Ref: 21/02071/FULHH
Date: 06/01/2022

HISTORIC BUILDINGS AND CONSERVATION ADVICE

RE: New Forge House Station Road Ardleigh Colchester

The application is for the construction of a single storey side extension to New Forge House.

Drawing title Ground floor plans

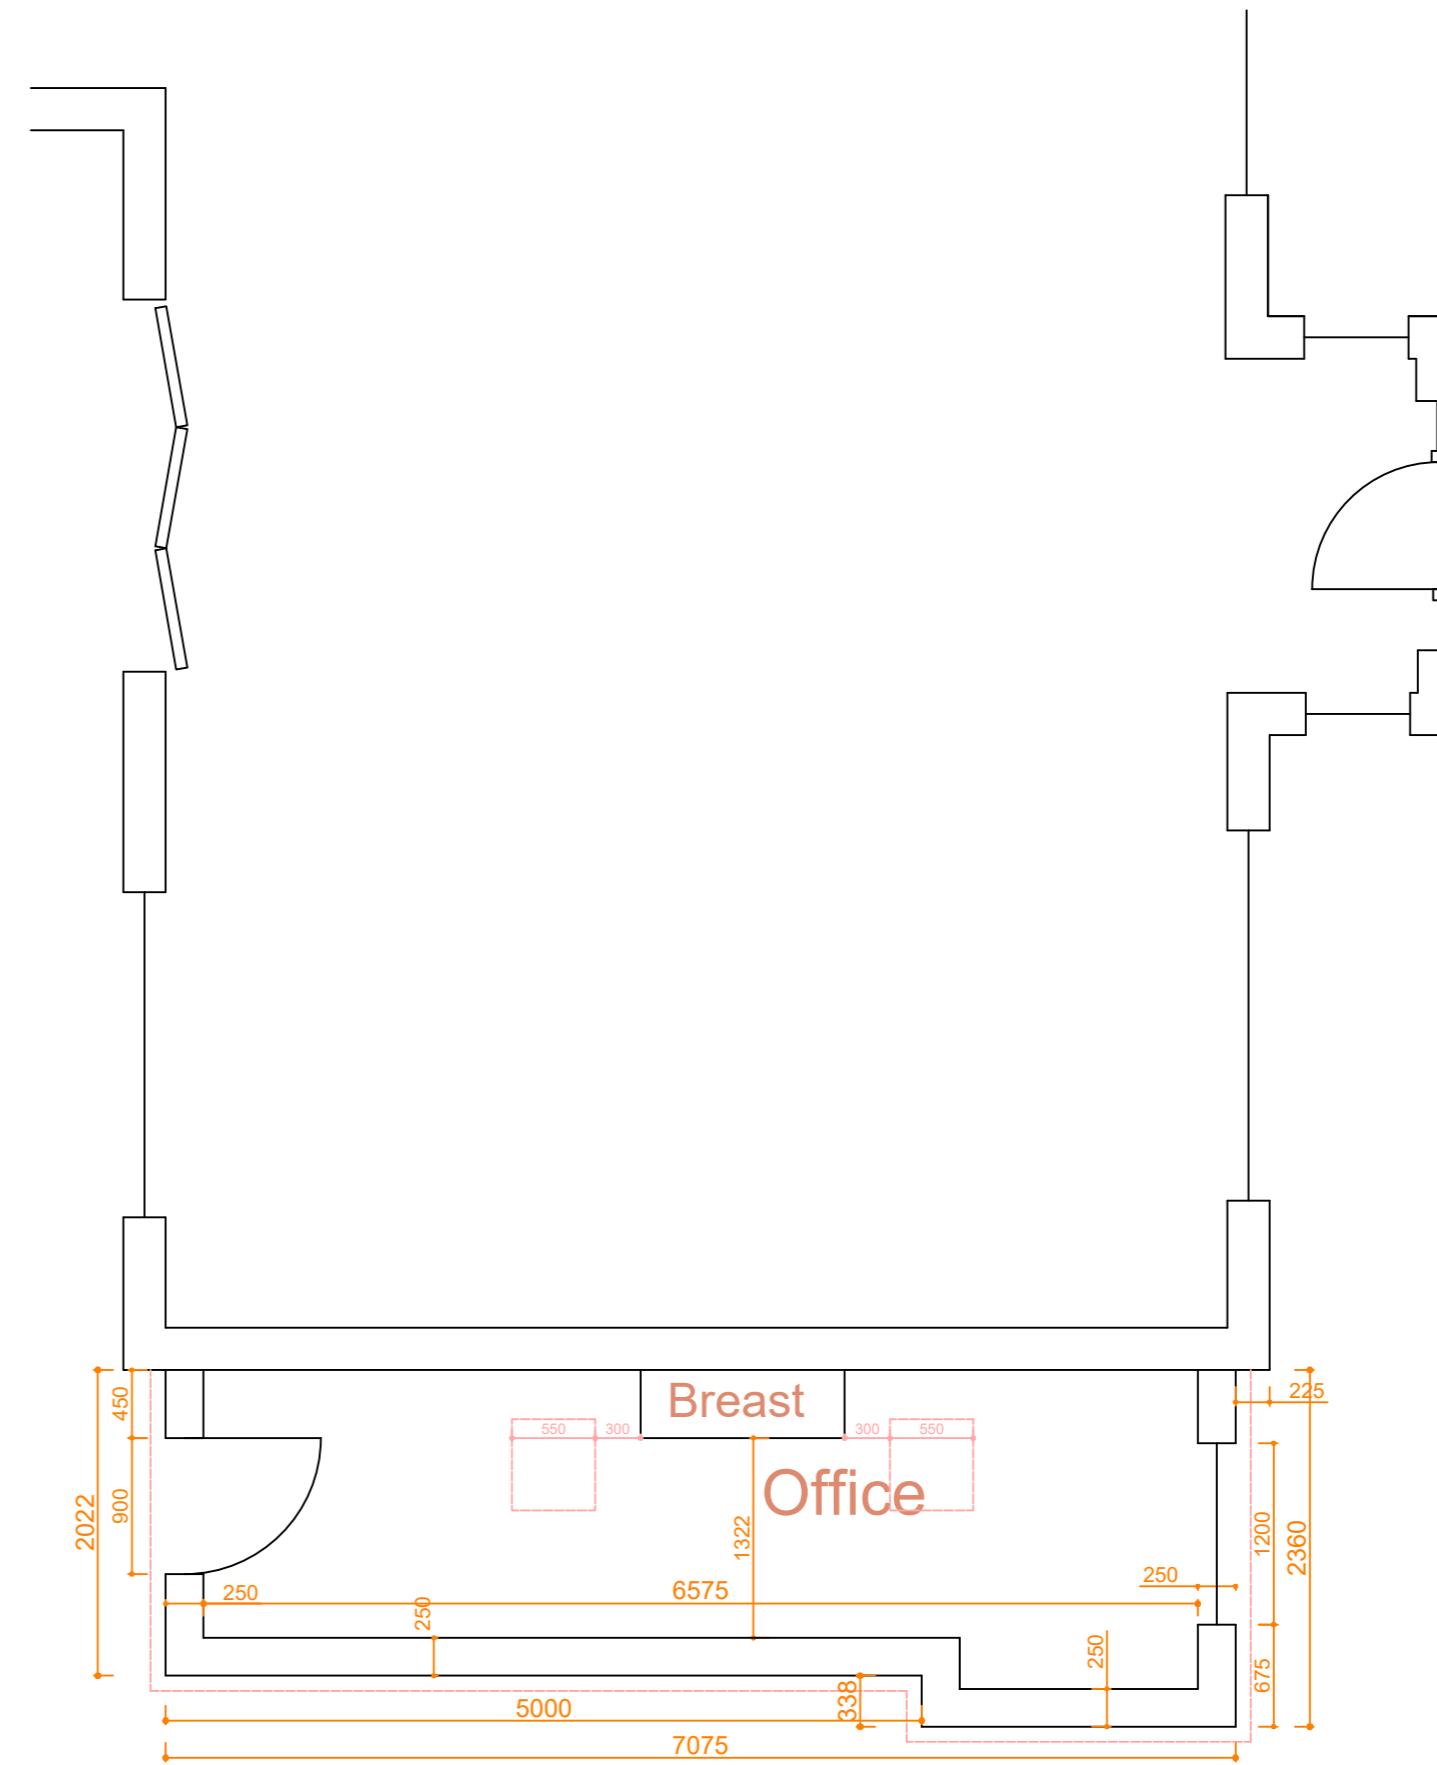
We cannot support the insertion of rooflights (a non-traditional form of fenestration) to the proposed roof as these would be visible from both the Conservation Area and the non-designated heritage asset.

The use of UPVC windows and doors is only considered acceptable if the host structure has UPVC. we would otherwise recommend timber or aluminium.

With the rooflights in this application, we consider the proposal will fail to preserve or enhance the character and appearance of the Conservation Area contrary to Section 72(1) of the Planning (Listed Buildings and Conservation Areas) Act 1990 and this harm to the designated heritage asset (Conservation Area) should be considered under paragraph 202 of the NPPF. In its current iteration we recommend this application is refused.

Should the rooflights be removed, we would have no objection.
